Figure 3.1 - Powerline Study Area and Survey Location

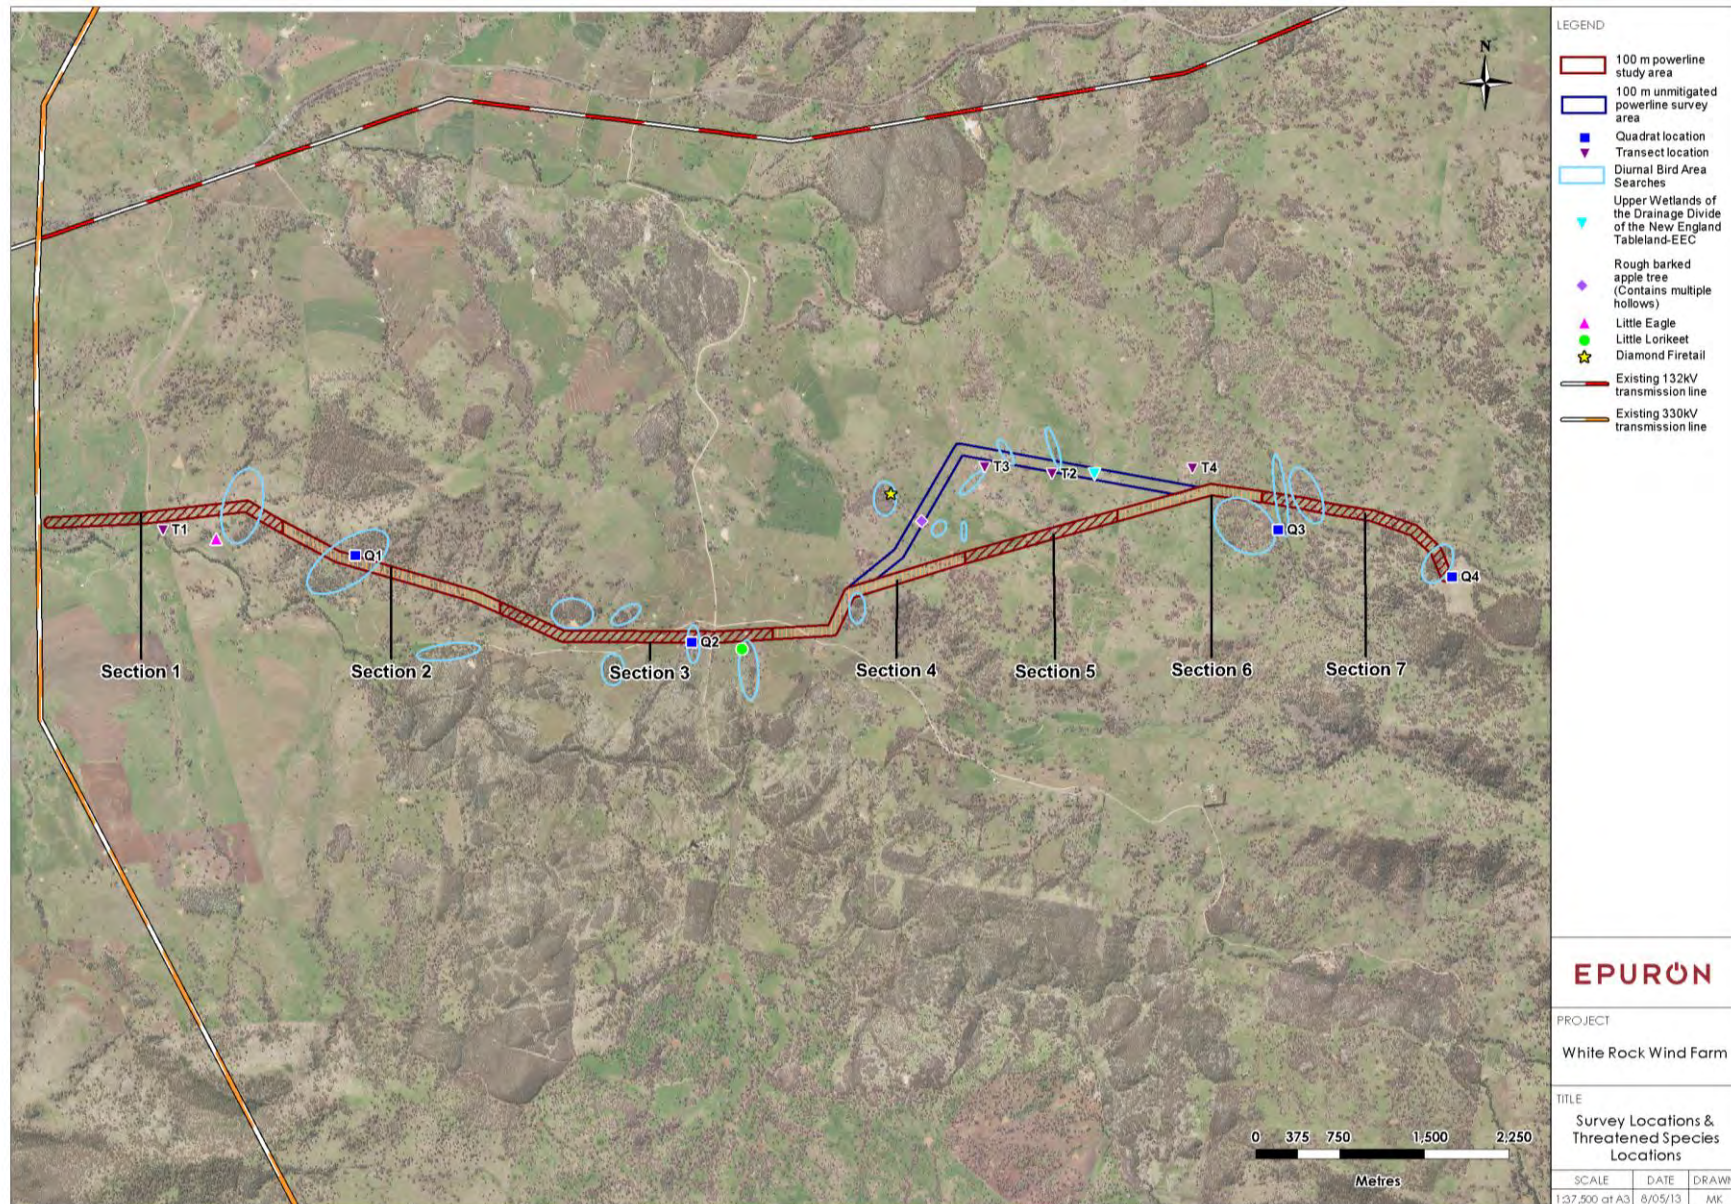
Recommendation: OEH suggests that a map of the threatened flora and fauna records is necessary on the basis of providing context.

See updated map in Figure 3.1 on page 12 showing the location of threatened flora and fauna records identified during the field survey.
